RE: **FedEx Fuel Station**
Daytona Rd NW
Grading Plan Stamp Date: 7/16/18
Hydrology File: K09D026C

Based on the submittal received on 7/18/18, the grading plan is approved for Site Plan for Building Permit and Building Permit.

**RE: FEDEX FUEL STATION
DAYTONA RD NW
GRADING PLAN STAMP DATE: 5/29/18
HYDROLOGY FILE: K09D026C**

<b>FEDEX GROUND</b> <b>ALBUQUERQUE, NM</b>	DRAWN BY LA
	<b>OVERALL GRADING</b> <b>AND DRAINAGE PLAN</b>	DATE 05/22/2018
	<b>TERRA WEST, LLC</b> 5571 MIDWAY PARK PLACE NE ALBUQUERQUE, NM 87109 (505) 856-3100 www.tierrawestllc.com	2018025-BASE-GR
	SHEET # <b>C-2</b>	JOB # 2018025

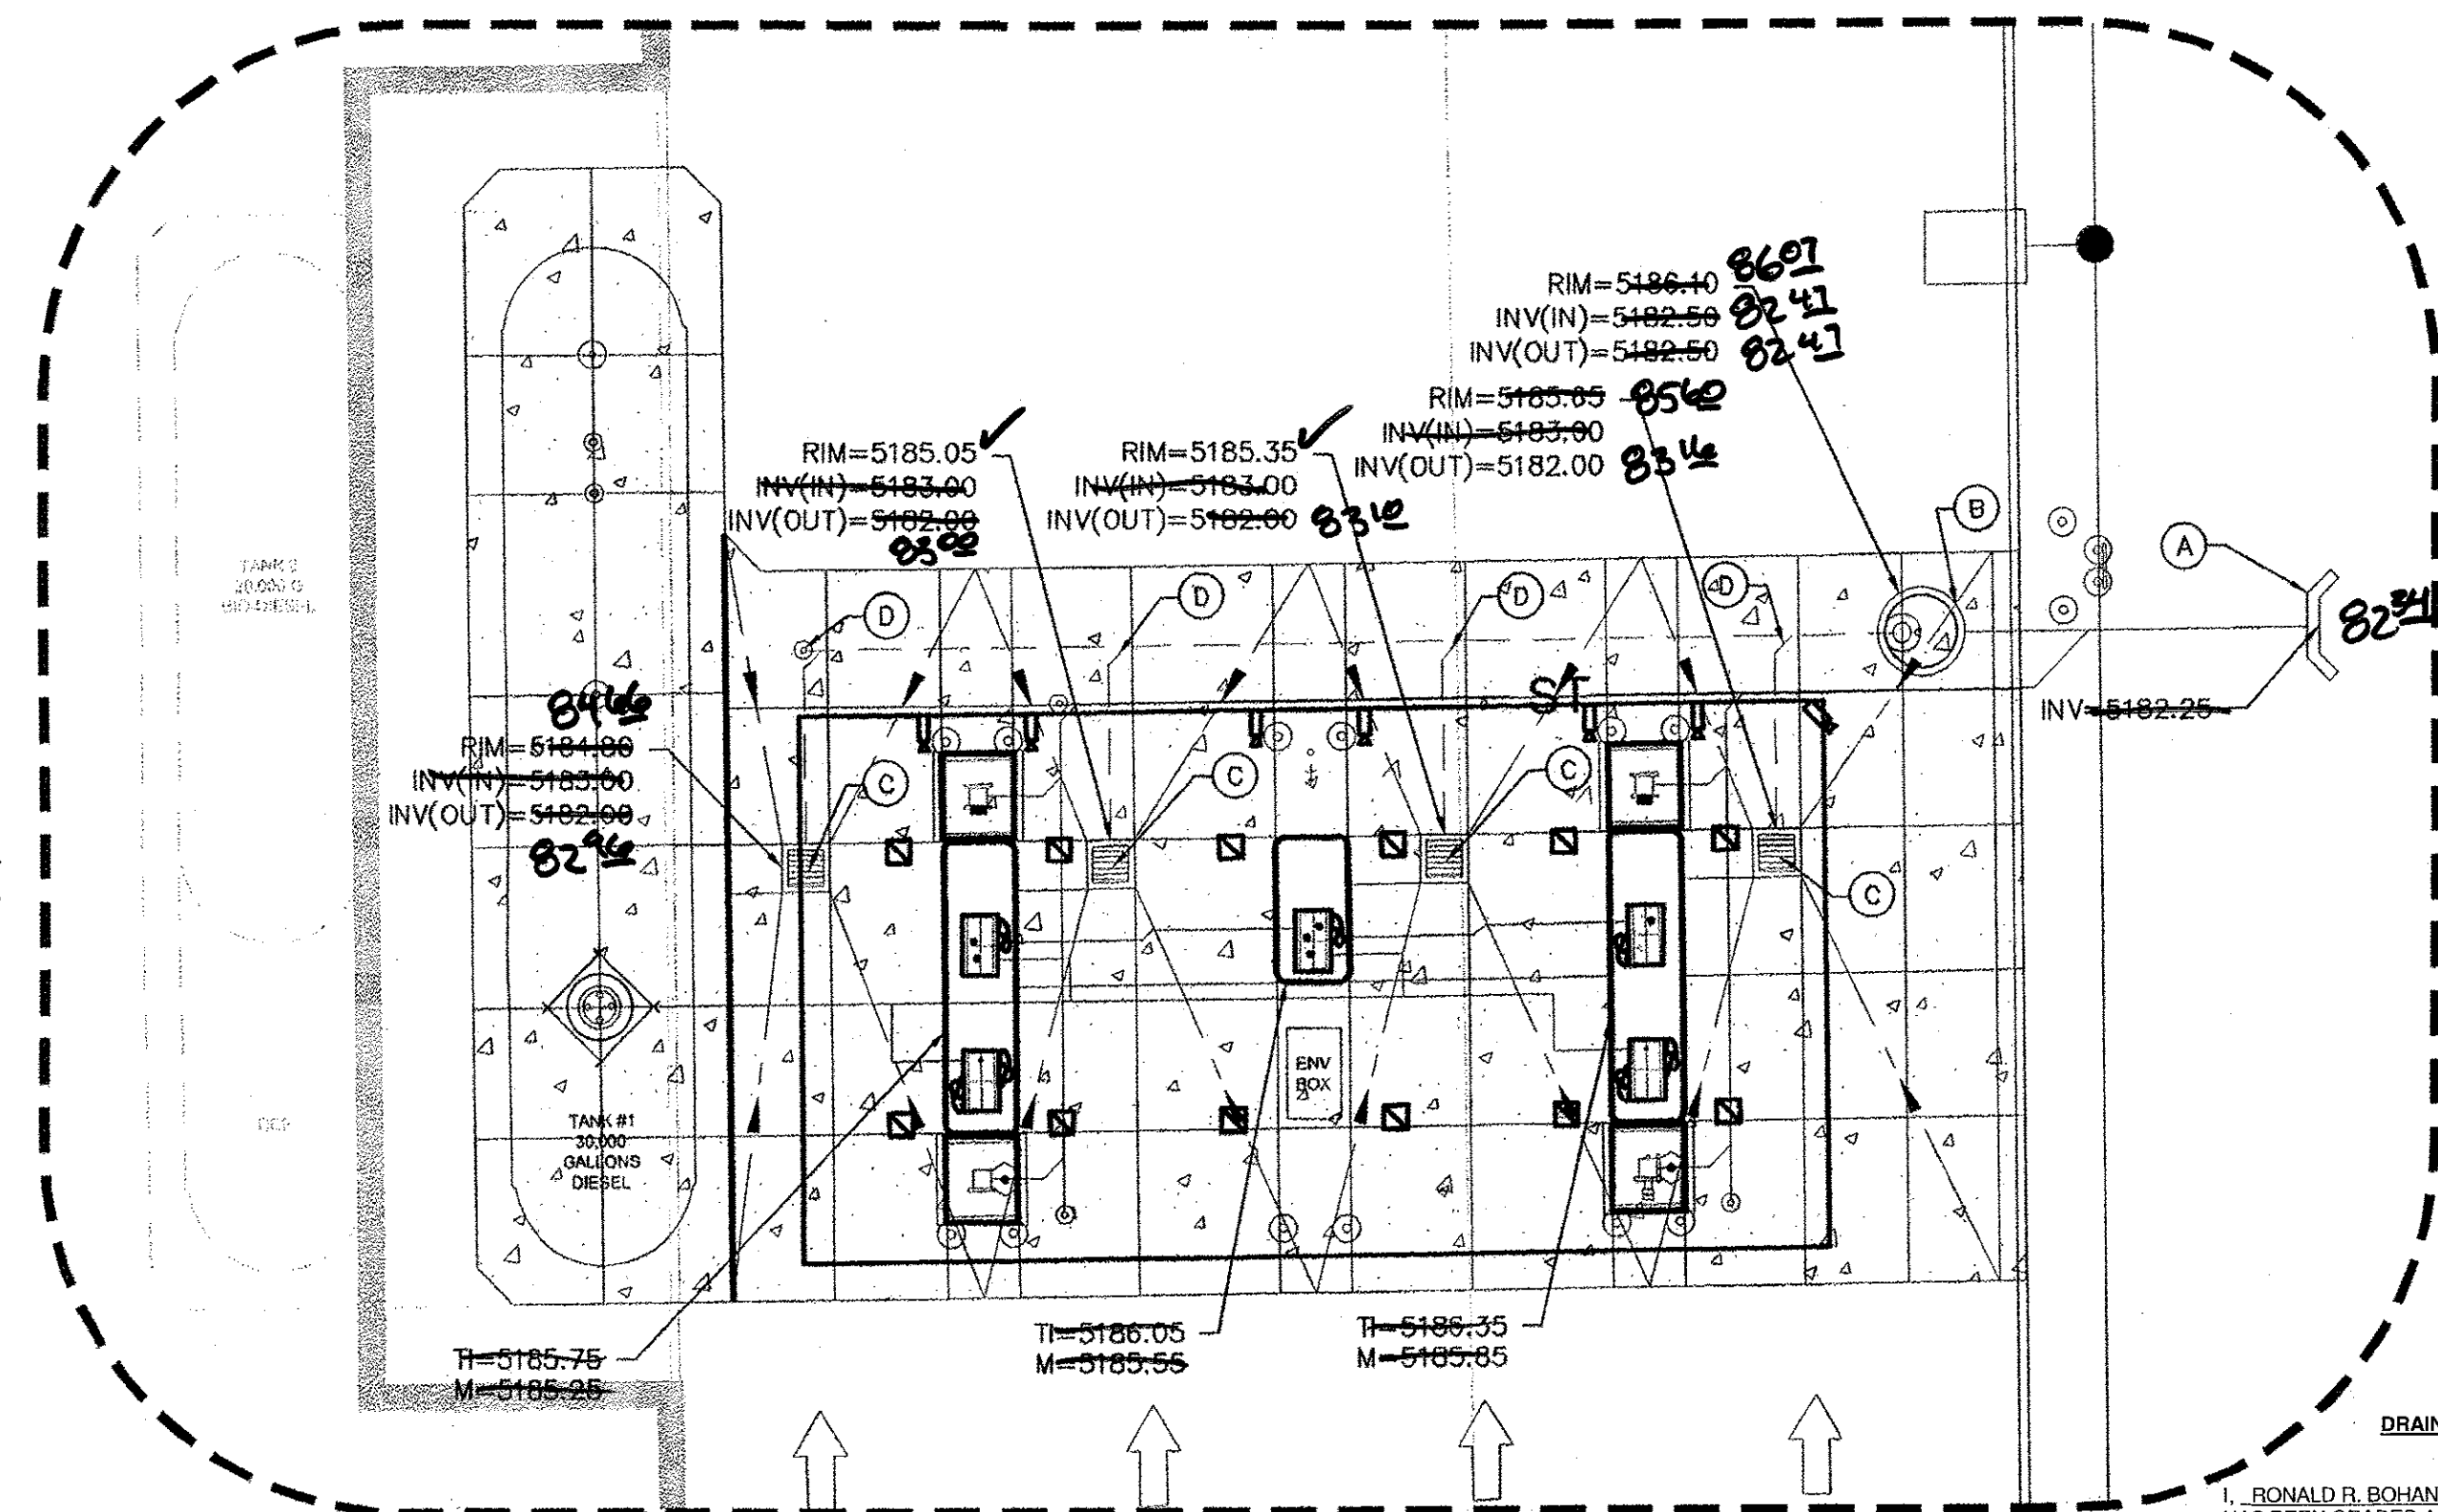
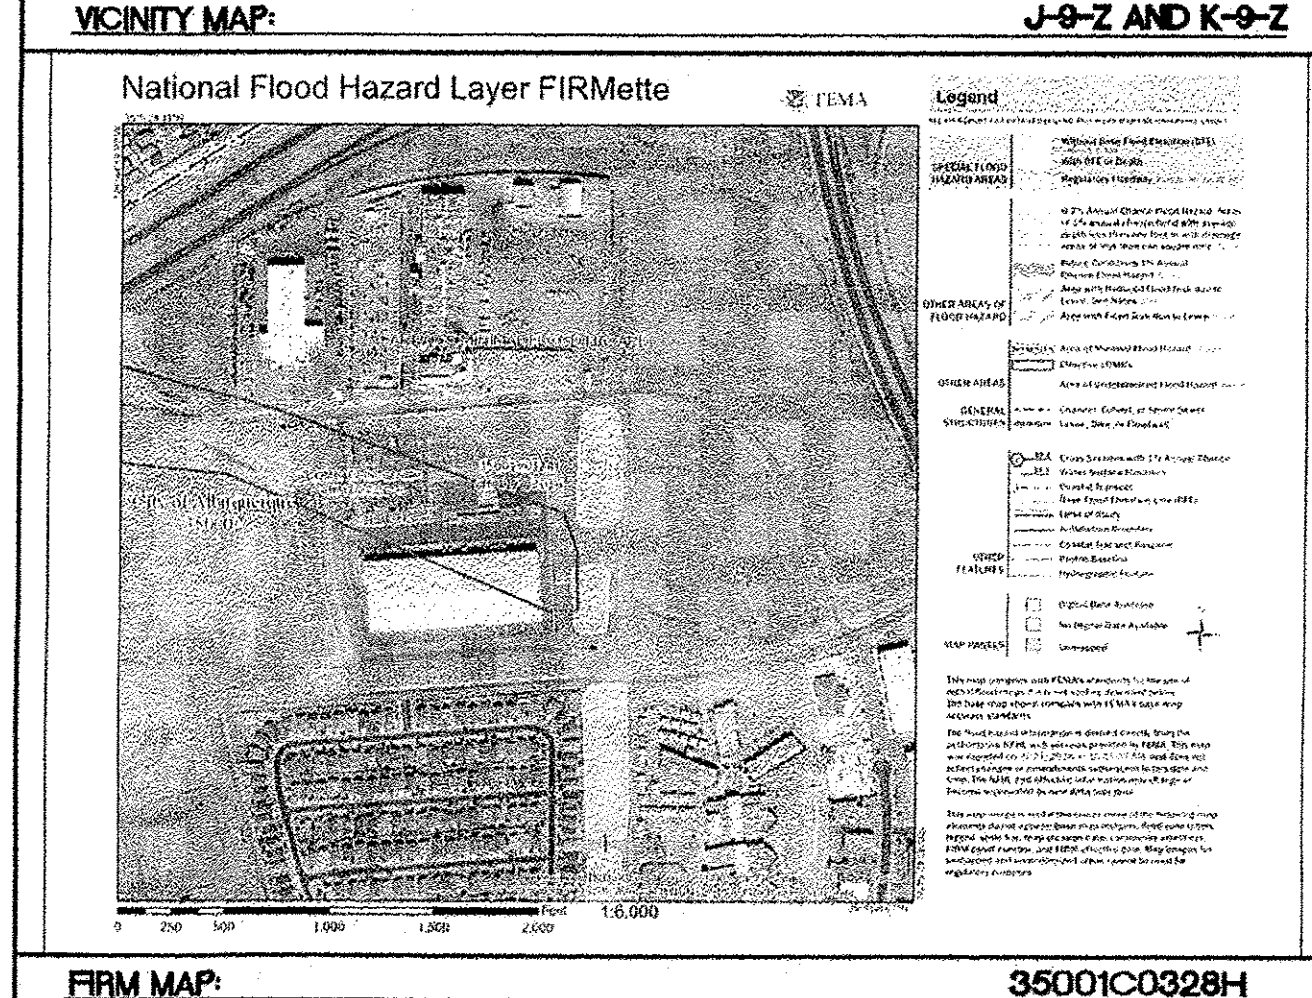
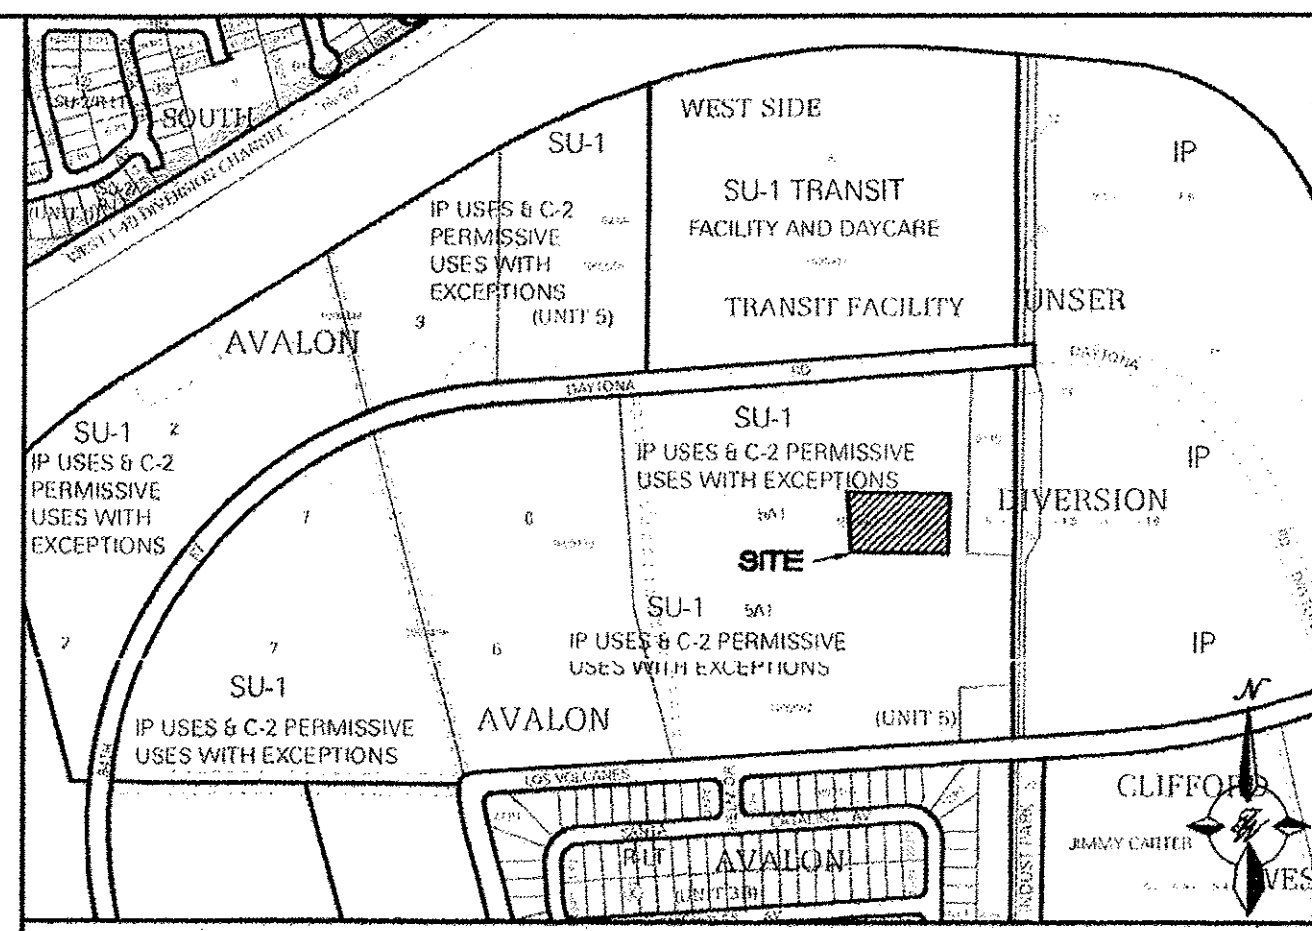
1. Include discussion of how the first flush is being retained on-site. Provide supporting calculations, drainage basin exhibits, etc. demonstrating that the area of new impervious (and redeveloped impervious, if any) will be routed to an adequately sized first flush facility.

Response: A paragraph discussing the first flush ponding was added to the grading plan. As noted in the original drainage report for the entire FedEx site, the detention pond was created with a first flush volume for all impervious areas, along with detention of developed flows. The volume of the desilting pond that will be moved to the north of the proposed fueling addition is not included in these permanent first flush and detention volumes.

ENGINEER'S SEAL  RONALD R. BOHANNAN P.E. #7868	FEDEX GROUND ALBUQUERQUE, NM DETAIL GRADING PLAN	DRAWN BY LA
		DATE 7/5/2018
 TIERRA WEST, LLC 5571 MIDWAY PARK PLACE NE ALBUQUERQUE, NM 87109 (505) 858-3100 www.tierrawestllc.com	2018025-BASE-GR	SHEET # C-2A
		JOB # 2018025

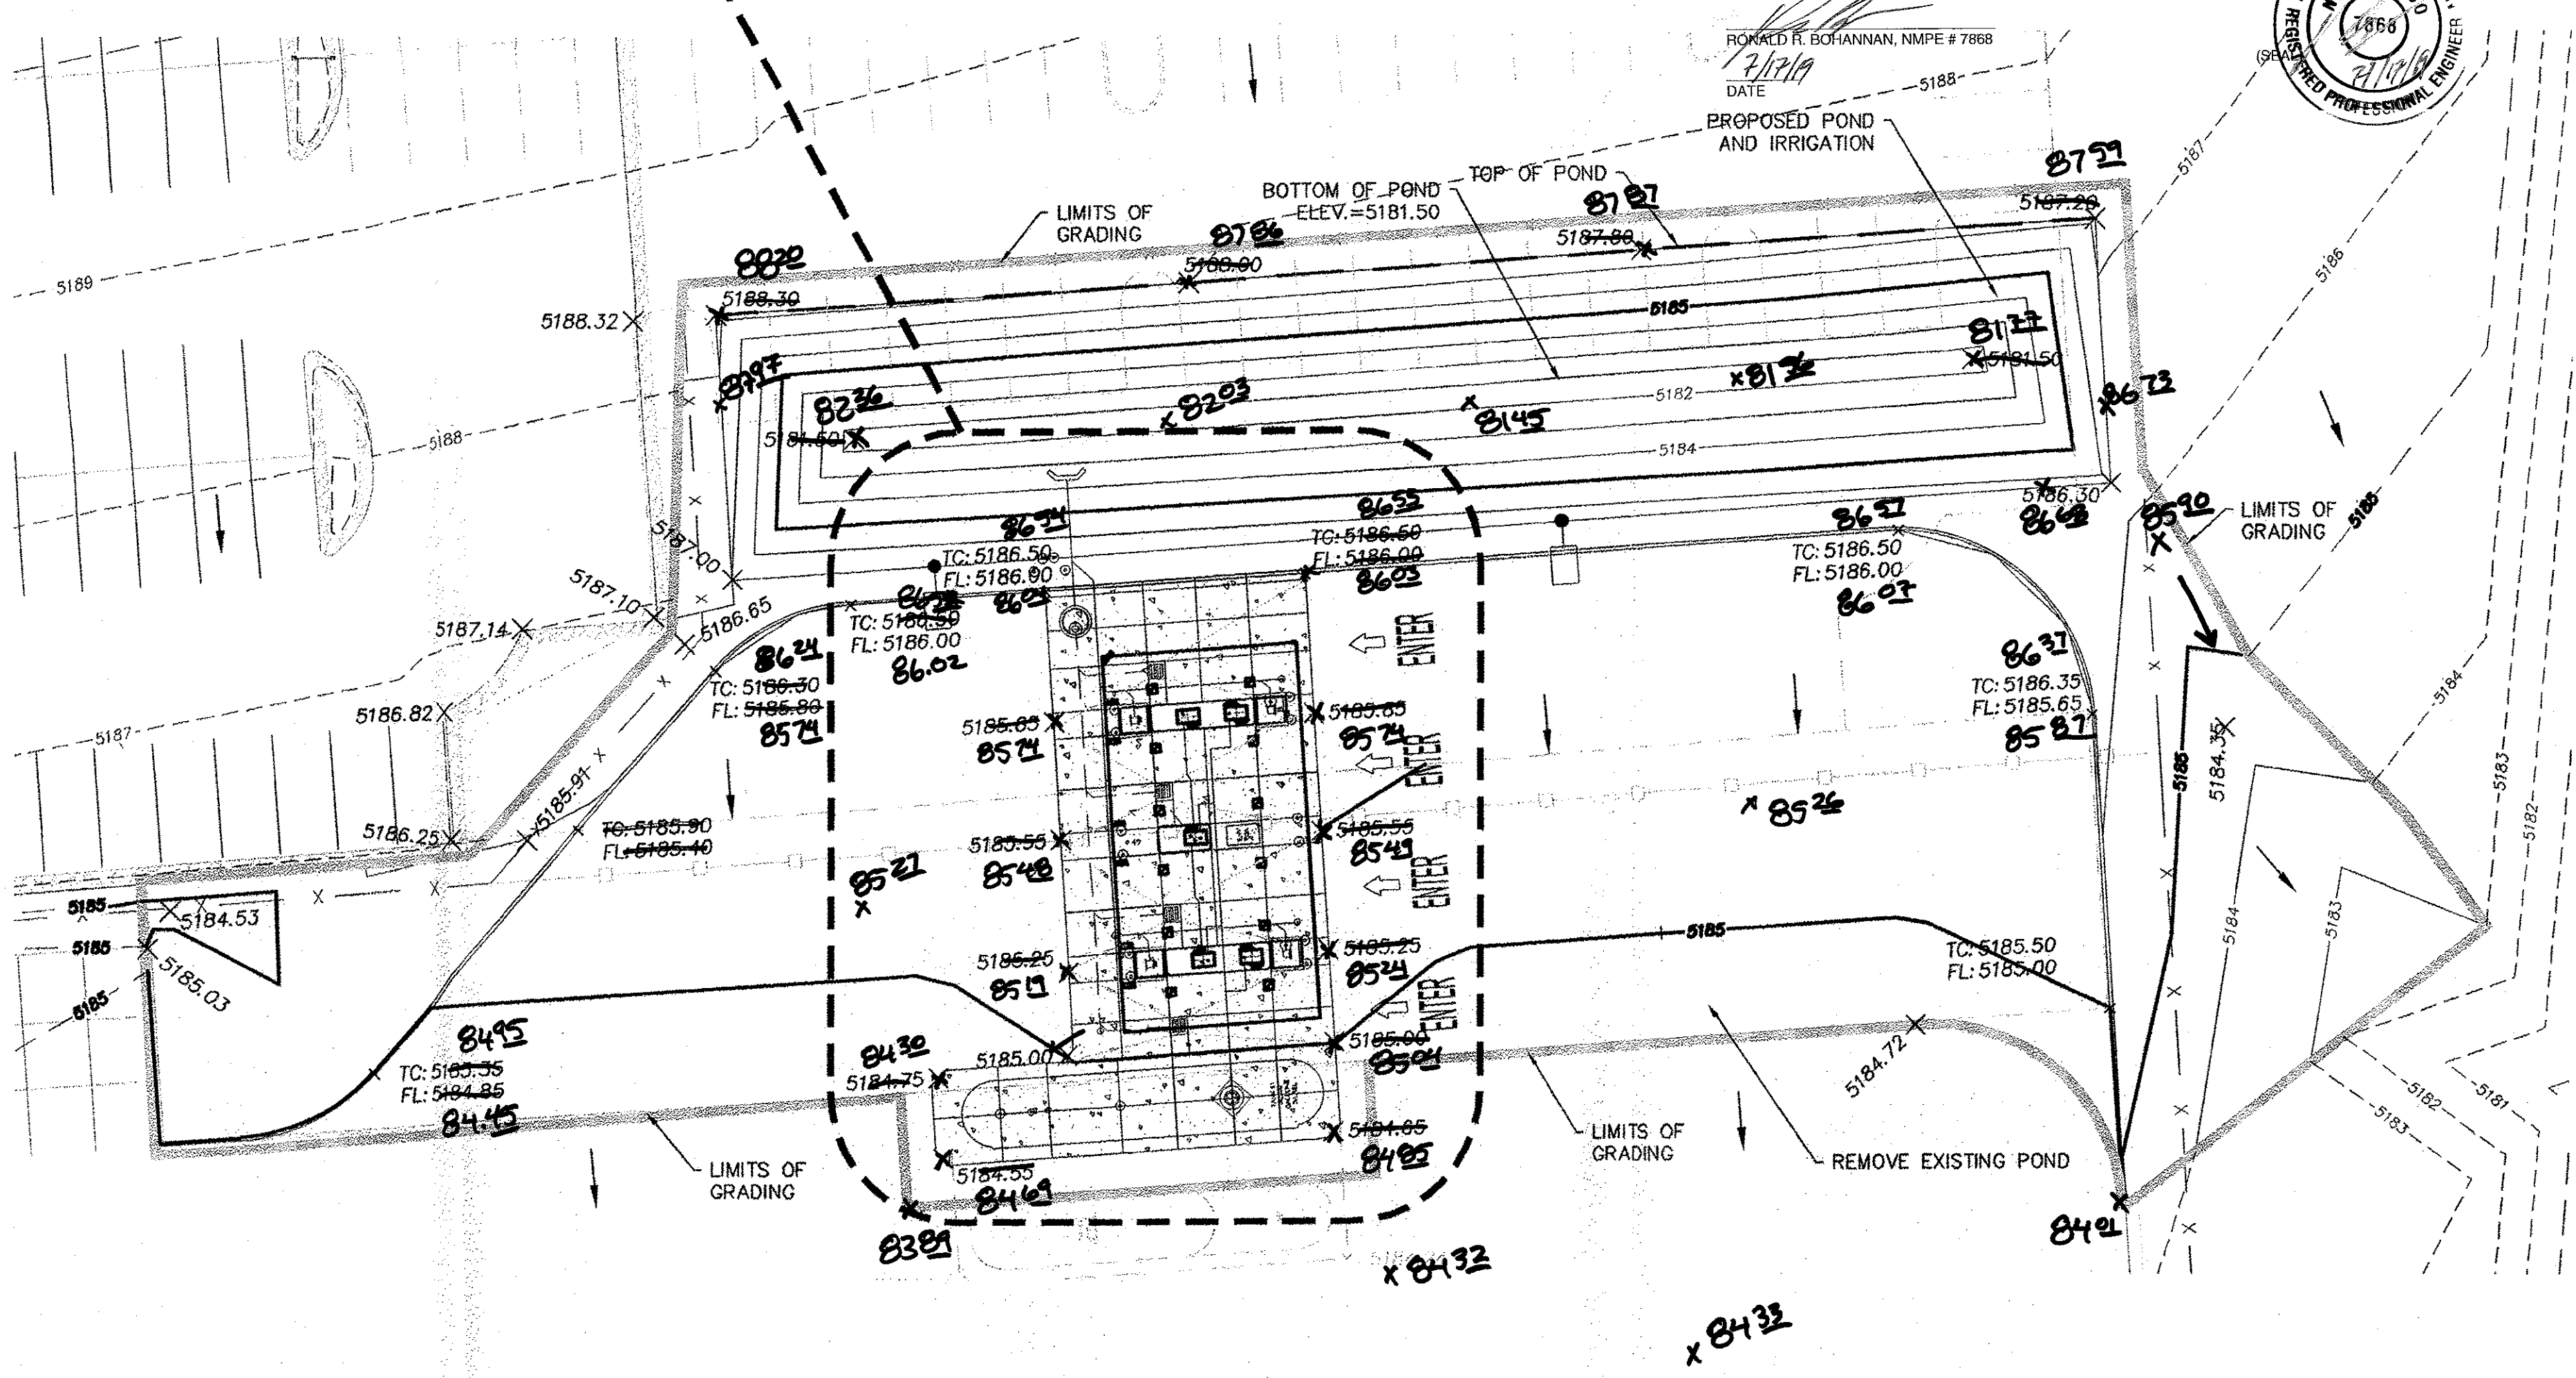
2. The proposed contours do not tie-in to existing along the edges of the project limits and appear to be drawn incorrectly. Increase the density of existing and proposed contour labeling and include minor labels.

3. The spot elevations do not agree with the contours; it is unclear if they existing or proposed. Please differentiate the labels to specify and confirm they agree with the contour data.

4. For fueling stations, demonstrate control of oil from vehicle parking areas per DPM Chapter 22.9.E, Table 1. The storm interceptor noted on sheet GR-2 appears to be intended for this, but it needs show that the parking area (around the fuel islands) is contained and drains to it. Please provide a specification for the storm interceptor and area inlets (notes B and C) as well.

5. The excavation and repaving for the UST should be included in the limits of work/grading.

Response: Proposed contours were corrected and additional labels were added.

Response: Proposed contours were corrected to match proposed elevations.

Response: Run off from proposed parking areas at the fuel pumps will be routed to area inlets and through a storm interceptor and to the desilting pond that will be relocated to just north of the fuel island improvements. Ultimately, if this pond were to overflow, runoff would be routed to the detention Pond 5 (with first flush storage). If in the future they want to eliminate the desilting pond, the outfall from the Stormceptor can be routed to an existing storm drain inlet located in a landscaped area SE of the fueling area. The make and model of storm interceptor required and its capacities were added to the plan keyed note (Stormceptor, model # SC 450i). The area inlets were noted to be 2'x2' concrete inlets with traffic rated grates.

Response: The limits of work/grading were adjusted to include the UST that will be installed with this project.
